Application No: EP/44/21/HH
Site Address: Craven Cottage 20 Tamarisk Way East Preston BN16 2TF
Description of works: First floor extension over existing garage and kitchen.

Thank you for your internet representation made on 17th May 2021 which has been recorded as an objection with the comments as follows:

Proposed First floor

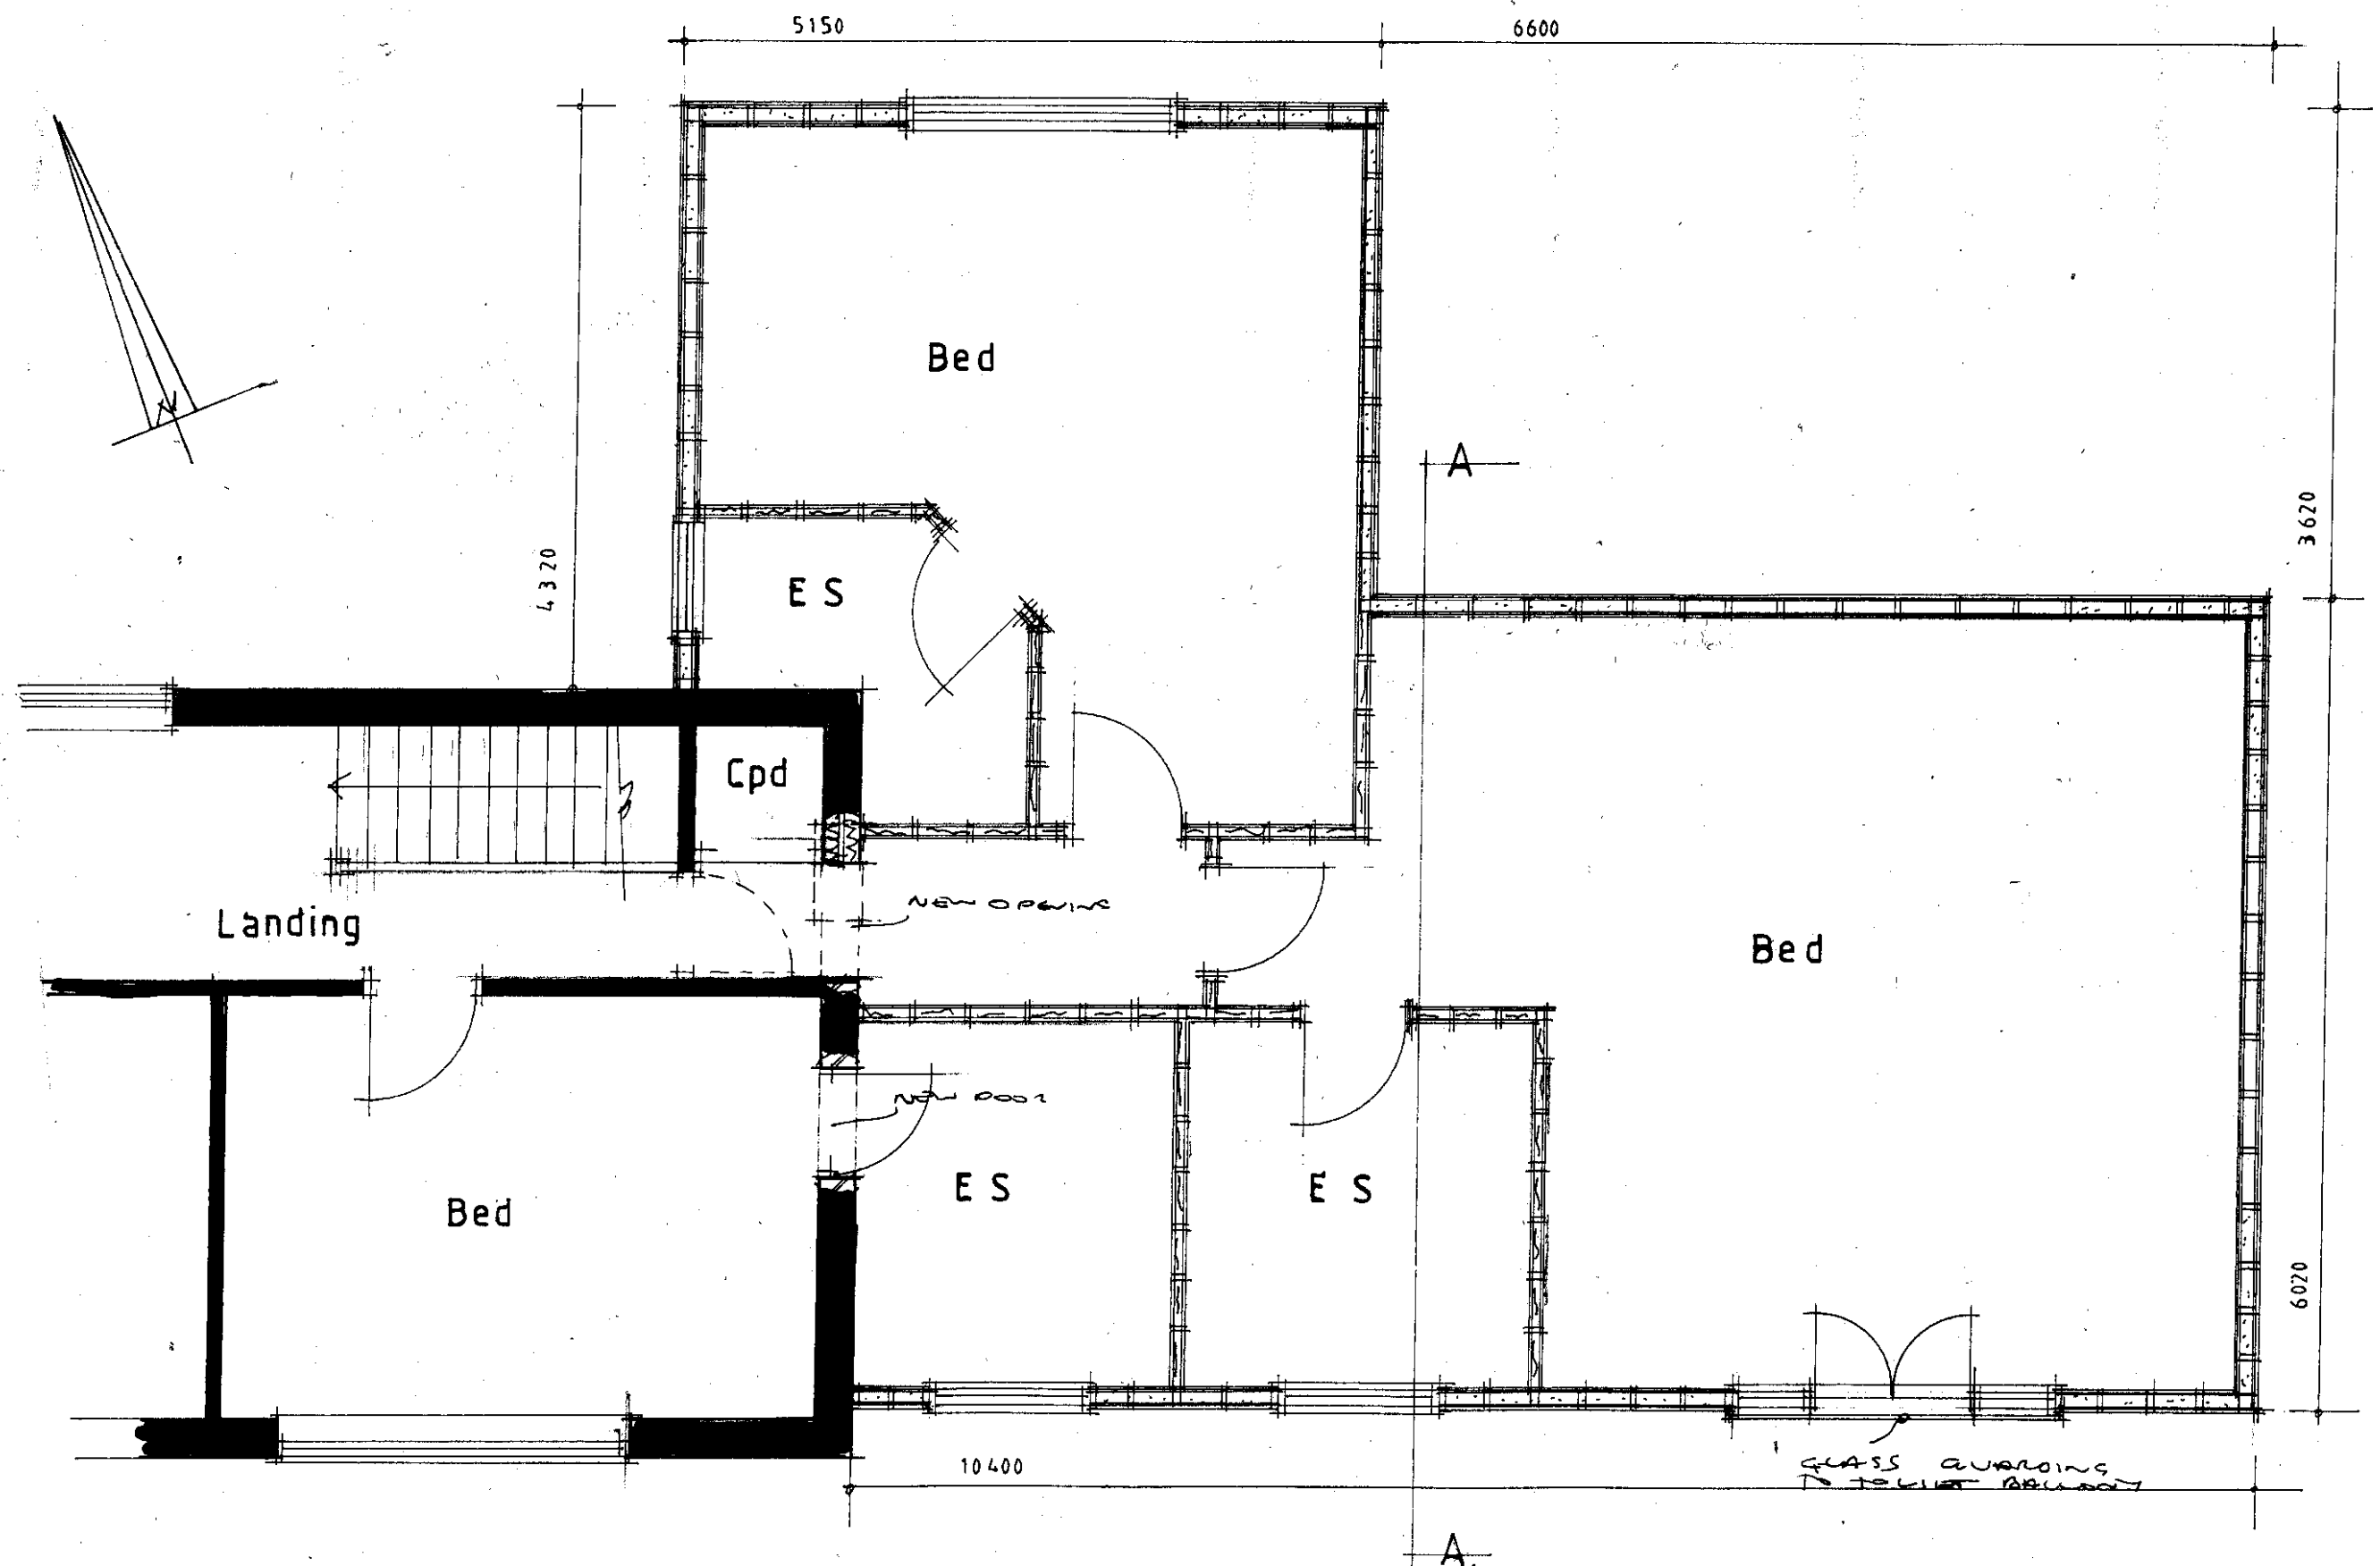
Our real concern about our neighbours' plans is the proposed NORTH-FACING FIRST FLOOR LARGE BEDROOM WINDOW which would OVERLOOK valued and secluded parts of our property - both house and garden. In this position, the window would also be in close proximity to our garden. Furthermore, the existing foliage is limited on both sides of the fence, even during summer months. It would be preferable for this first floor north elevation window to TO BE RELOCATED TO THE EAST ELEVATION to avoid a negative impact on our property.
